Your Ref: SSD 5363
Our Ref: S12/0014
DA13080688478 PC

29 August 2013

**State Significant Development – SEPP (State and Regional Development) 2011
Kempsey District Hospital Redevelopment, River Street, West Kempsey
Lots 1 - 8 Section 20A DP 759080, Lots 1 & 14 Section 23A DP 759080 and Lot 20 DP
112084**

Figure 12 – Plan of Buildings that require examination in respect to additional fire protection measures.

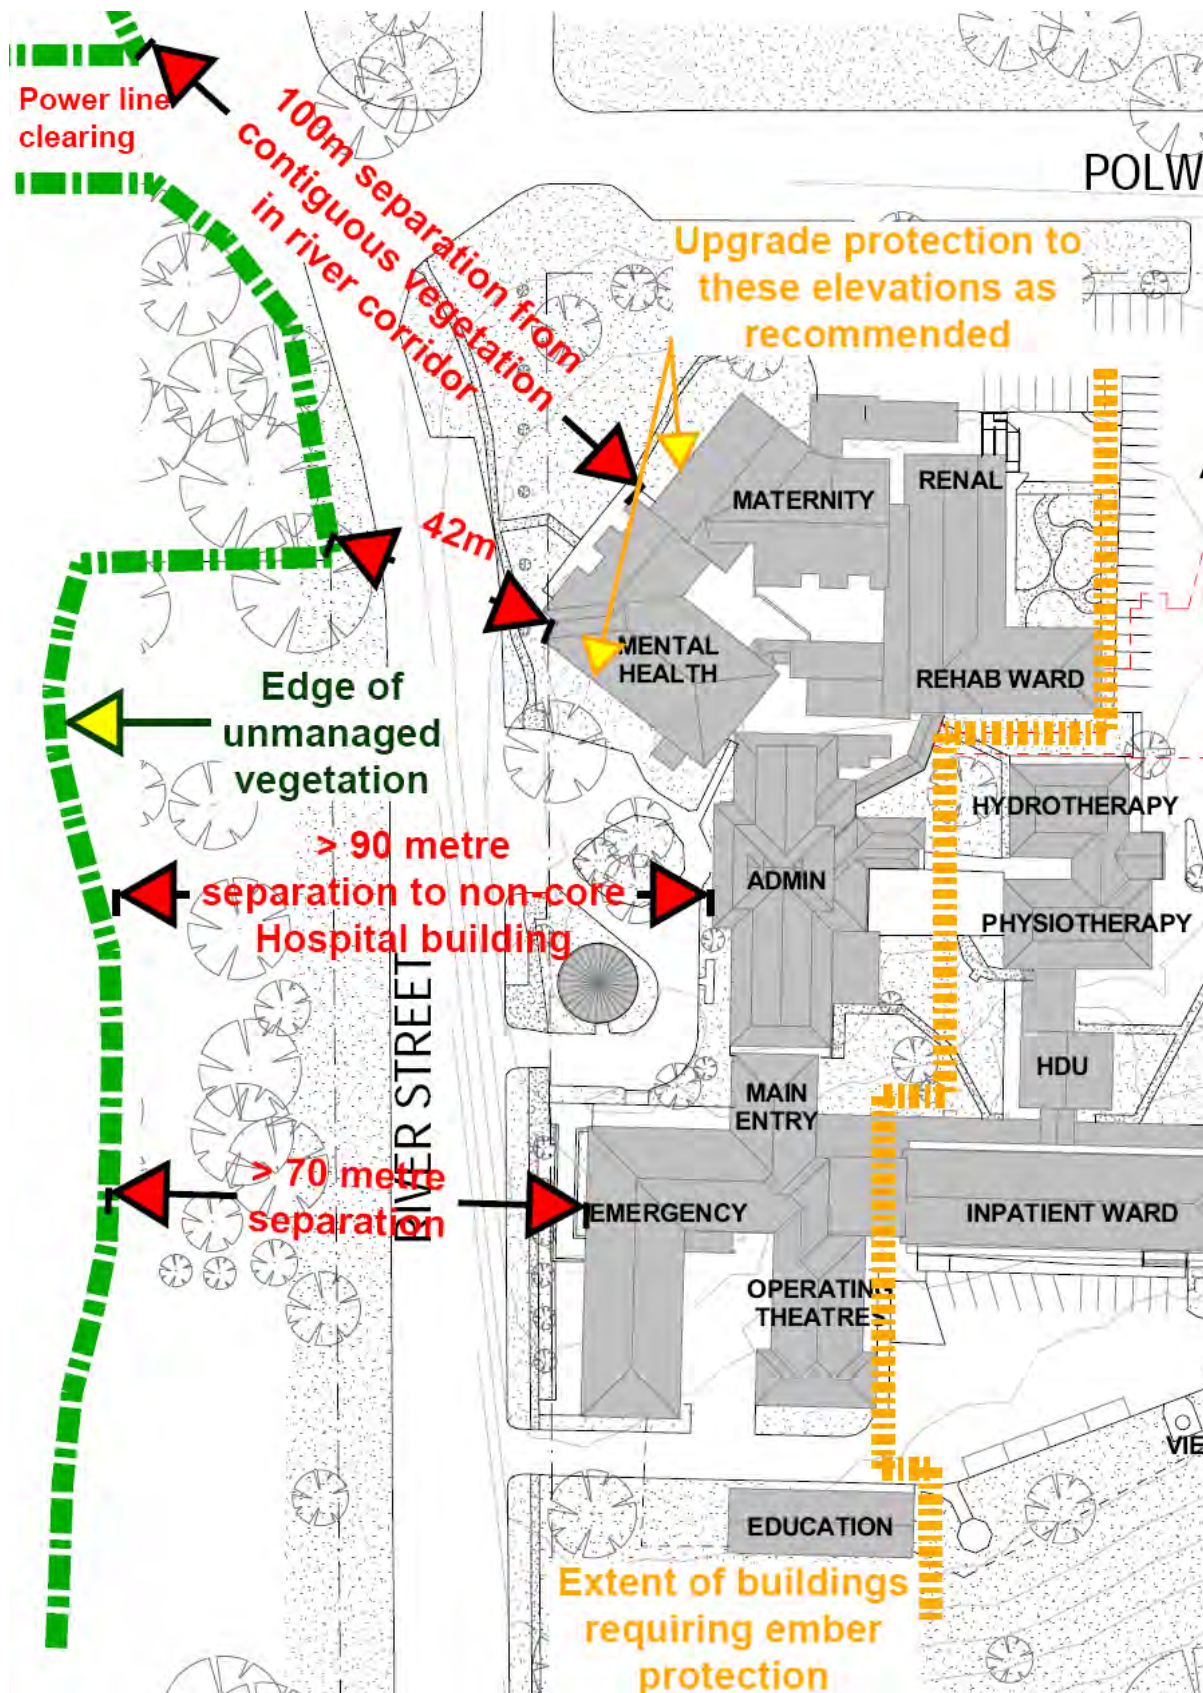
4. The existing buildings located less than 100m from bushfire prone land on the western side of River Street (as shown in Figure 12 of the Bushfire Protection Assessment prepared by Australian Bushfire Protection Planners Pty Ltd, dated 20 April 2013) shall be upgraded for ember protection. This is to be achieved by enclosing all openings (excluding roof tile spaces) or covering openings with a non-corrosive metal screen mesh with a maximum aperture of 2mm. Where applicable, this includes any sub floor areas, openable windows, vents, weepholes and eaves. External doors are to be fitted with draft excluders.
5. Roofing of the mental health and maternity buildings shall be gutterless or guttering and valleys are to be screened to prevent the build up of flammable material. Any materials used shall be non-combustible.
